WEST SUSSEX COUNTY COUNCIL CONSULTATION

TO:	Arun District Council FAO: Andrew Wood
FROM:	WSCC - Highways Authority
DATE:	8 March 2021
LOCATION:	10 South Drive, Ferring, BN12 5QU
SUBJECT:	FG/18/21/PL Demolition & erection of 1 No. dwelling. This site is in CIL Zone 4 and is CIL Liable as new dwelling.
DATE OF SITE VISIT:	N/A
RECOMMENDATION:	Advice
S106 CONTRIBUTION TOTAL:	N/A

PROPOSED GROUND FLOOR PLAN 1:50

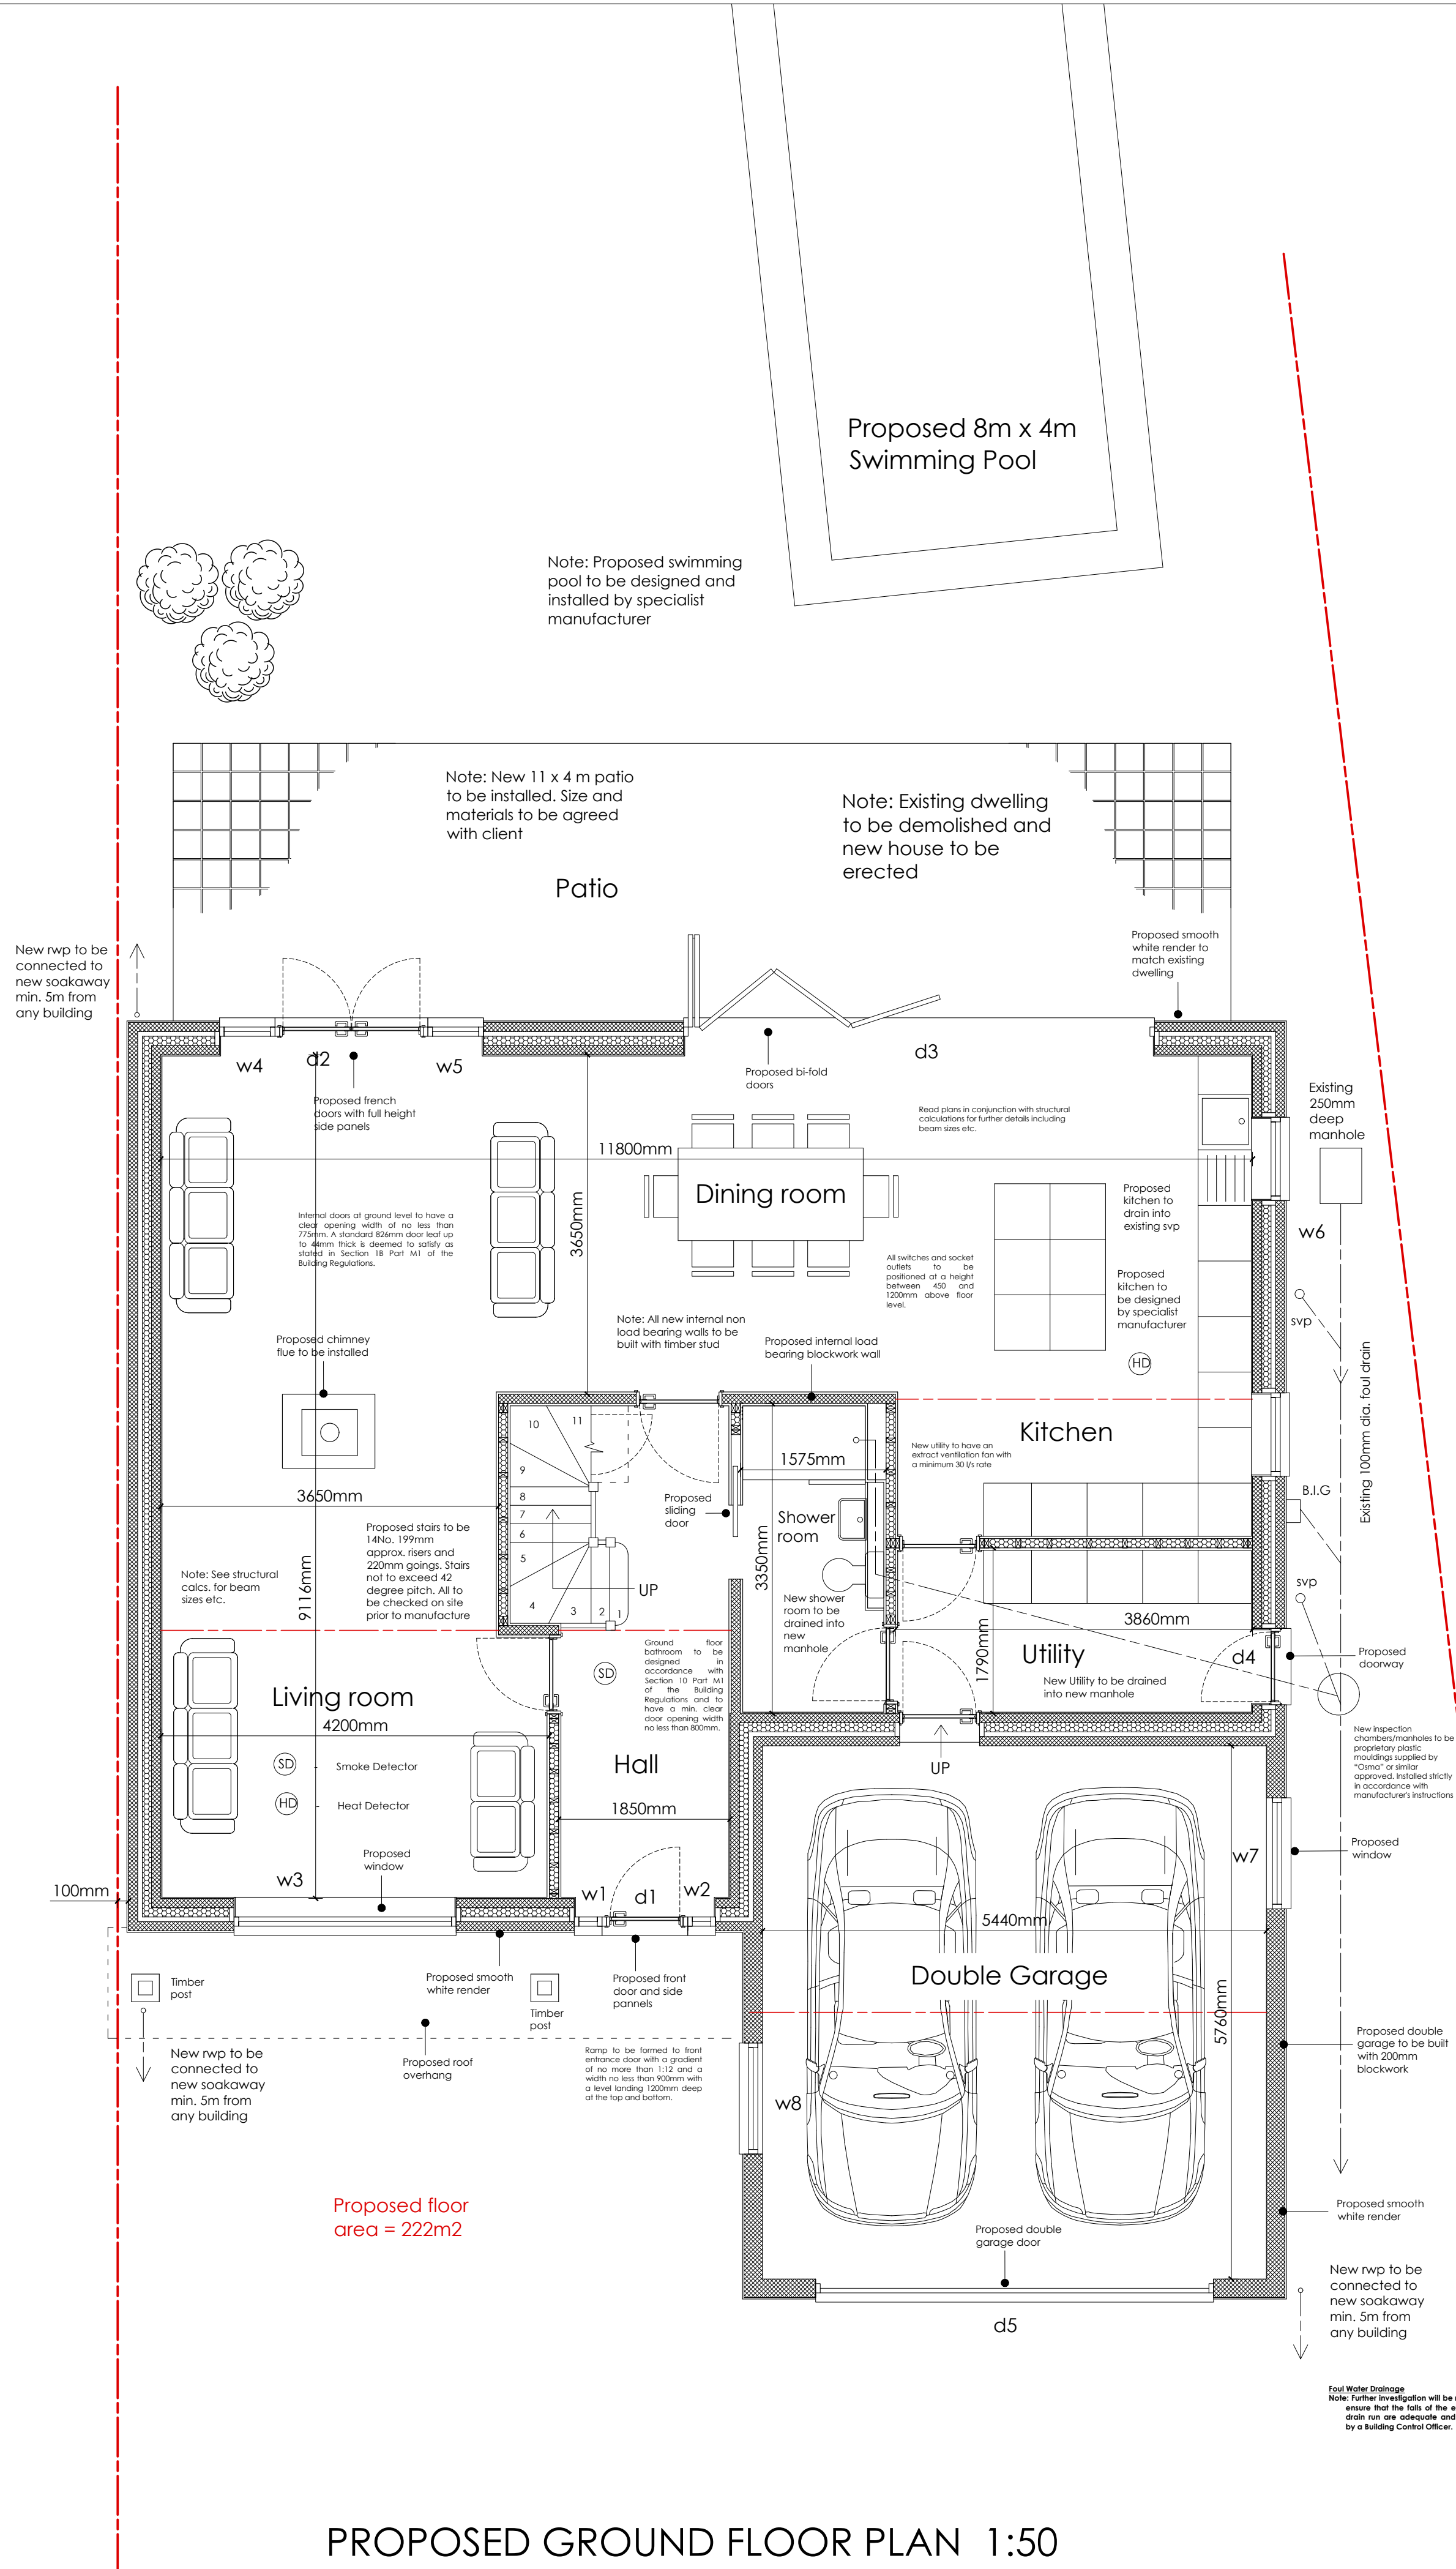
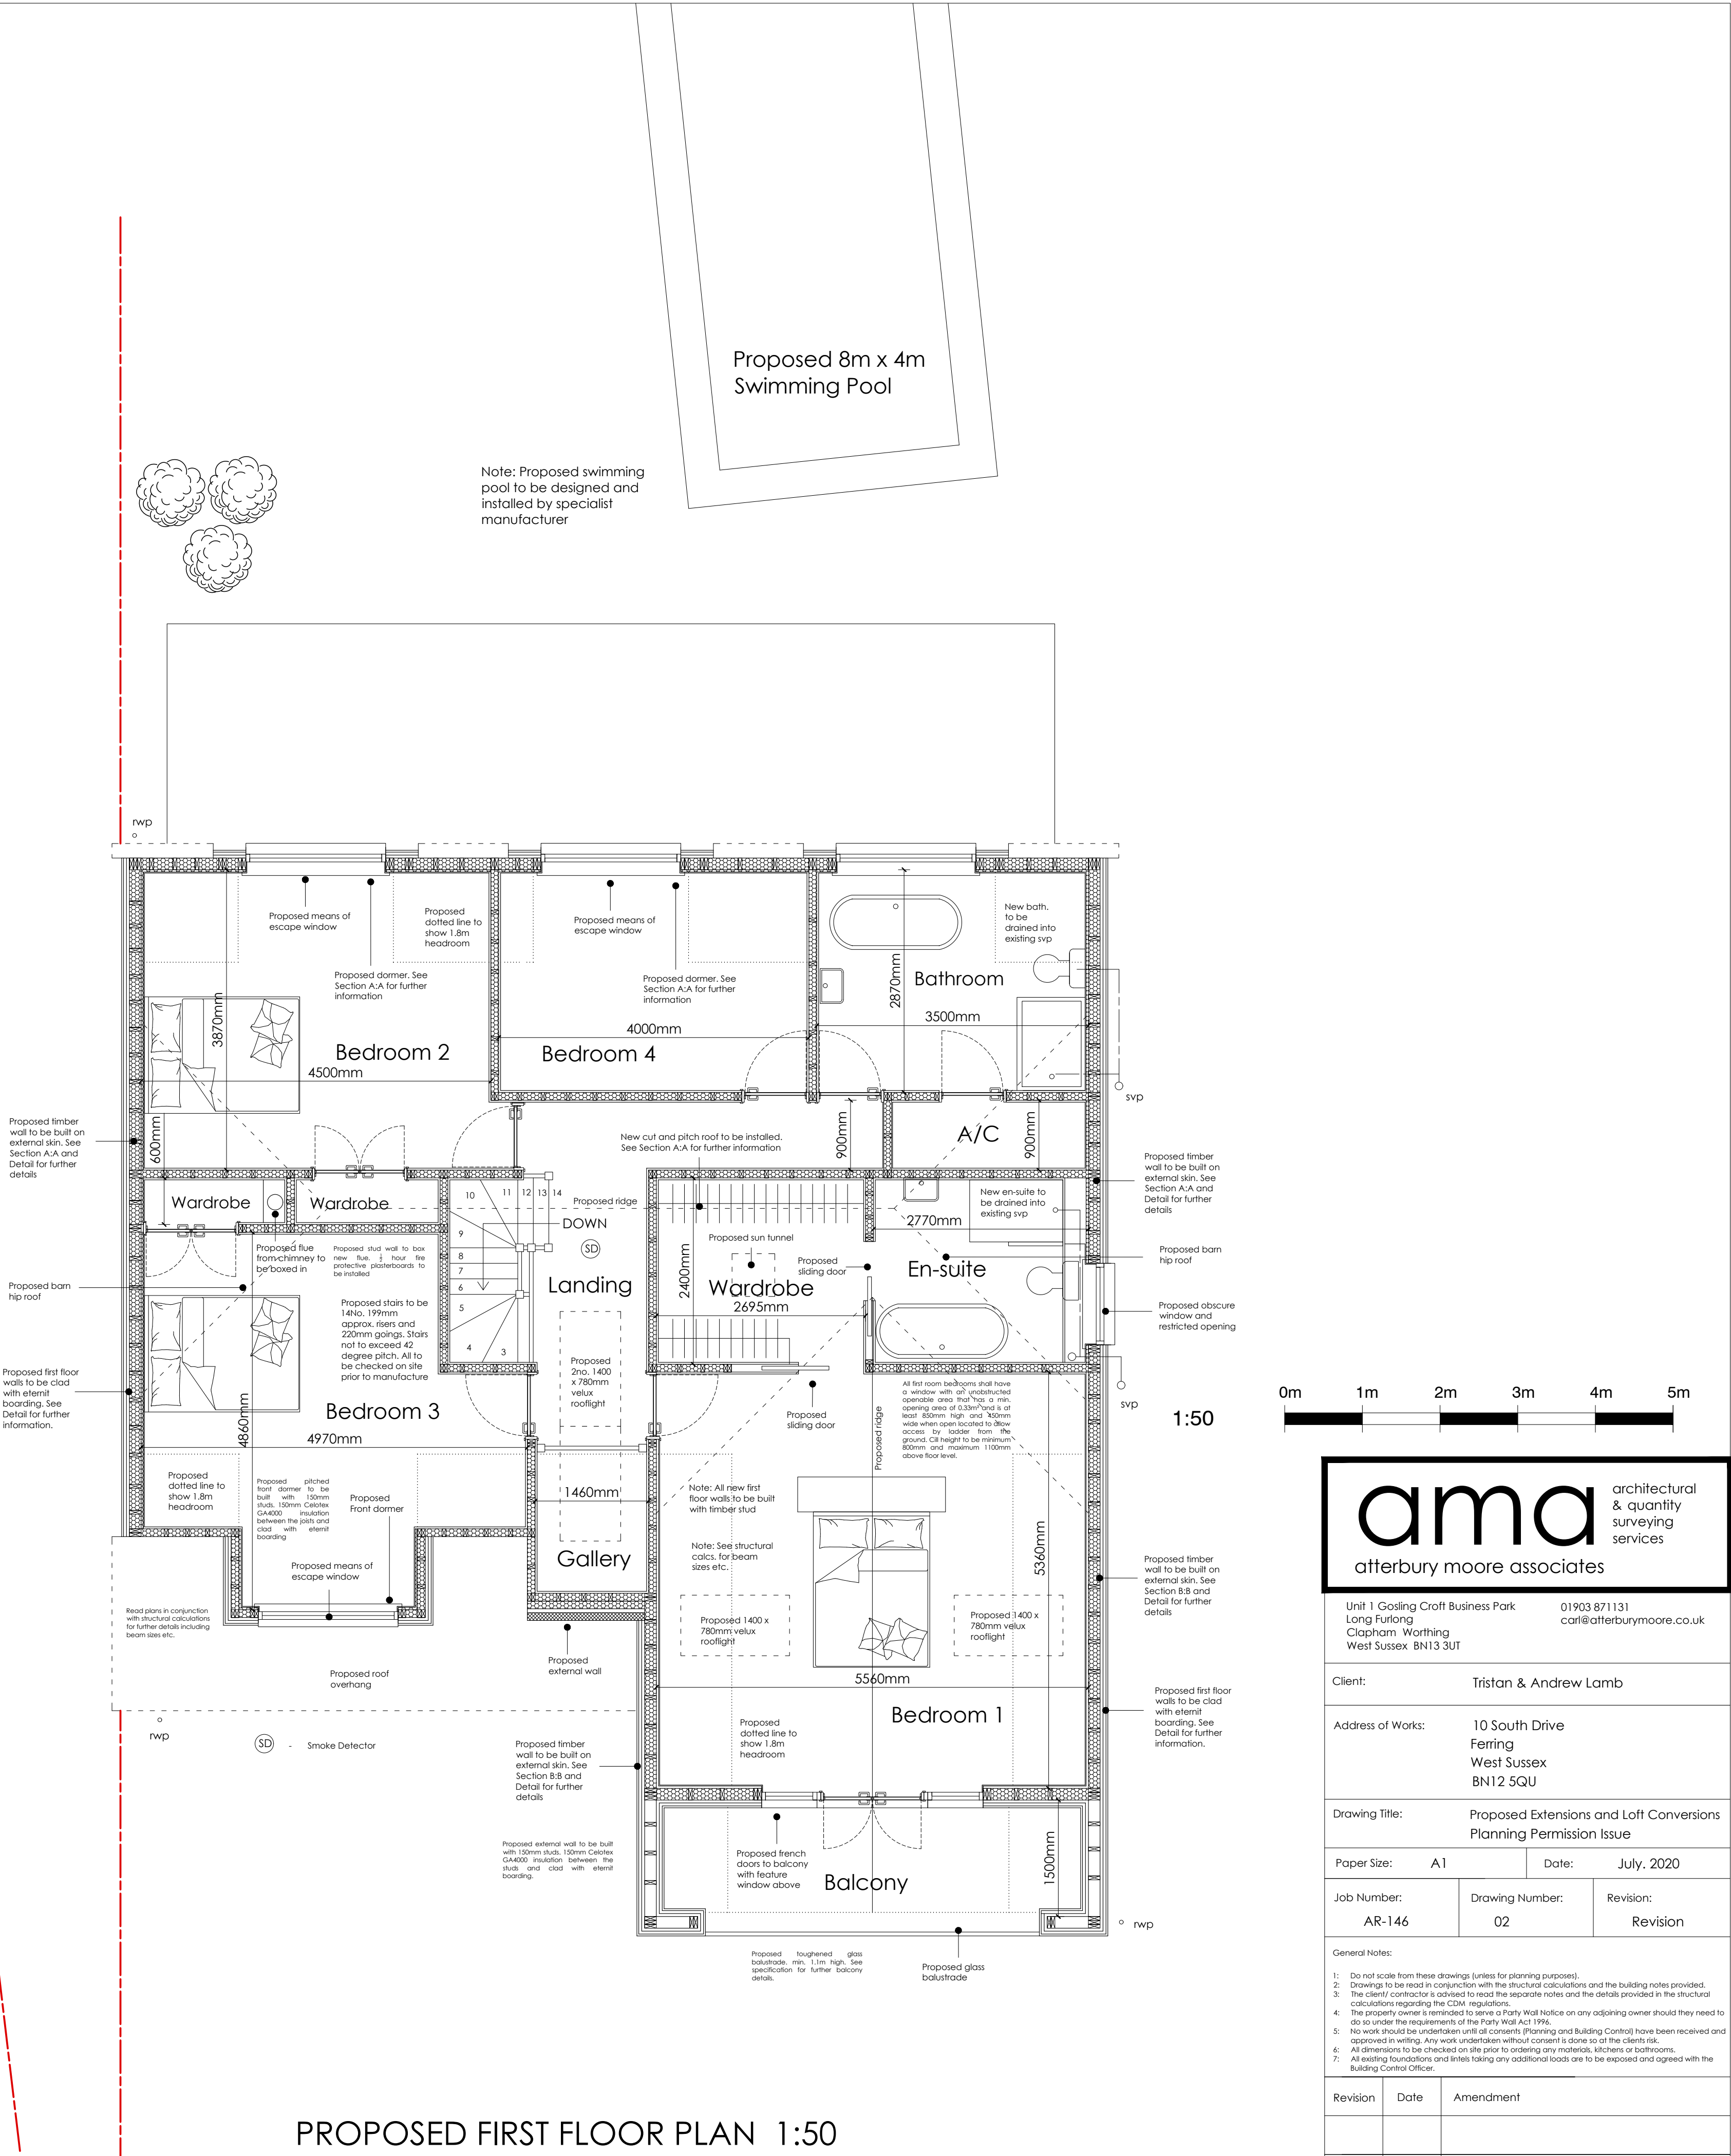
The LHA does note that the proposed garage has approximate internal dimensions of 5.4m x 5.8m. This does not meet the minimum specifications for double-car garages of 6m x 6m as set out in Manual for Streets (MfS). Therefore, in its current design, the LHA cannot consider the garage for parking provision, as it may be too small for modern cars to fit inside. The LHA advises the applicant to enlarge the garage to meet MfS specifications.

The applicant has not demonstrated cycle parking. Cycling is a viable option in the area and the applicant should demonstrate secure and covered cycle parking provision in accordance with Arun Parking Standards. The LHA notes that if the garage is enlarged to MfS specifications, the LHA will consider the garage for cycle parking also.

However, the LHA advises the applicant to enlarge the proposed garage to meet MfS specifications.

SITE PLAN 1:500

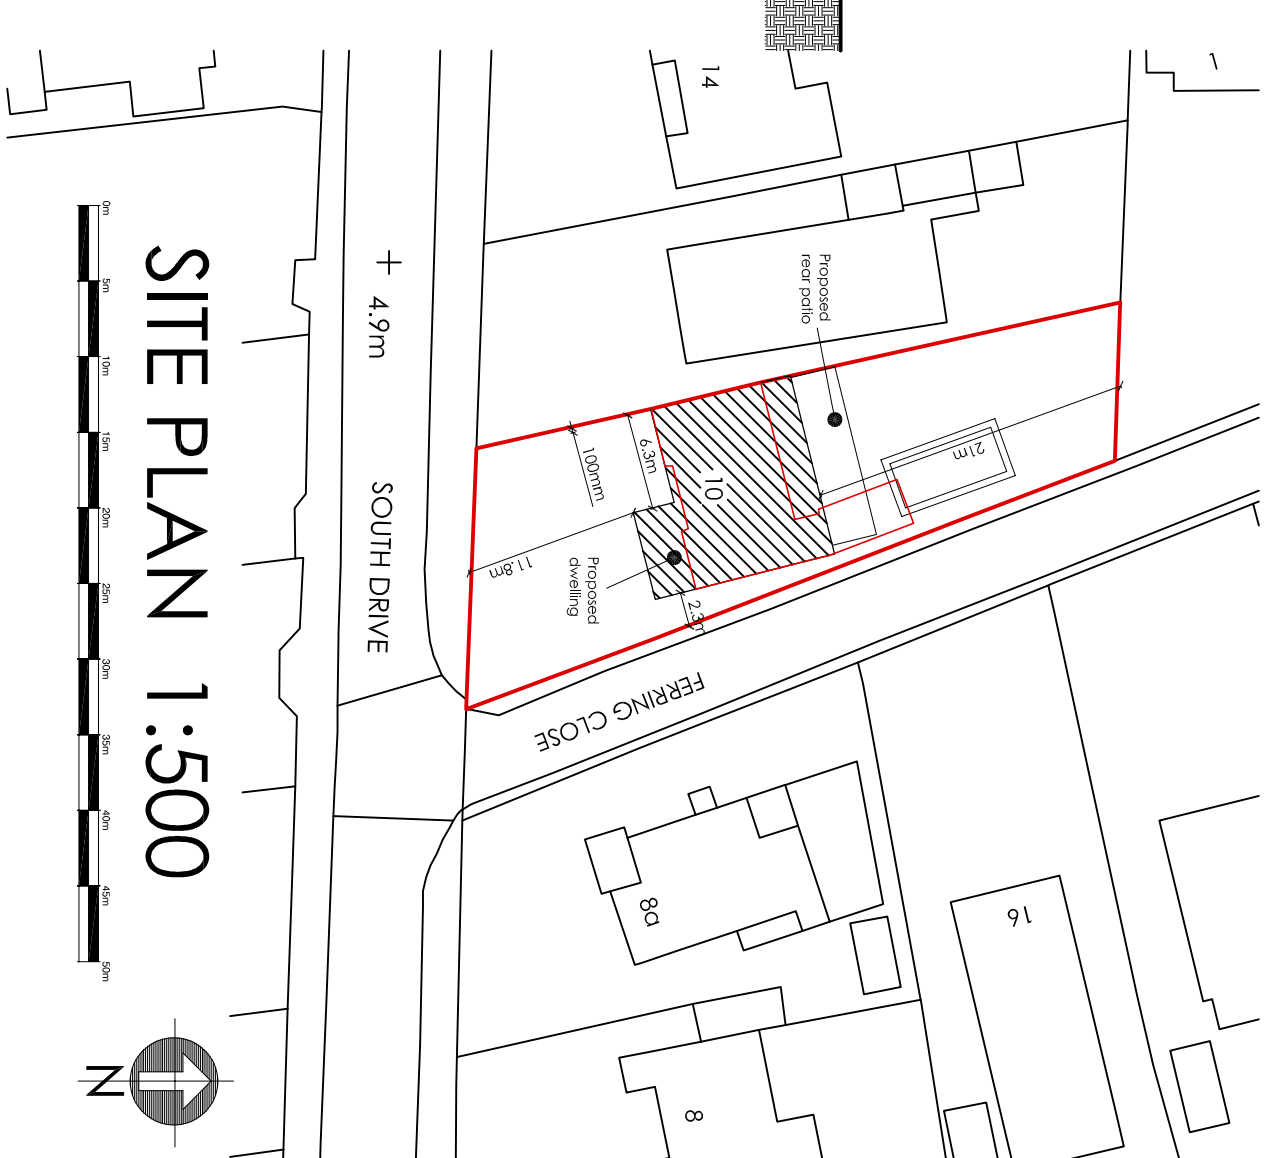
It is unclear from the plans if the applicant proposes any changes to the existing access arrangement. If the applicant does propose any access works, the LHA advises the applicant to contact the proprietor of the privately maintained road to obtain formal approval for the proposed access works.

The applicant proposes a double-car garage for this development. Under Arun Parking Standards (adopted January 2020), the LHA would anticipate that three parking spaces would be sufficient for a dwelling of this size and location. There appears to be space within the site for a third parking space to be accommodated.
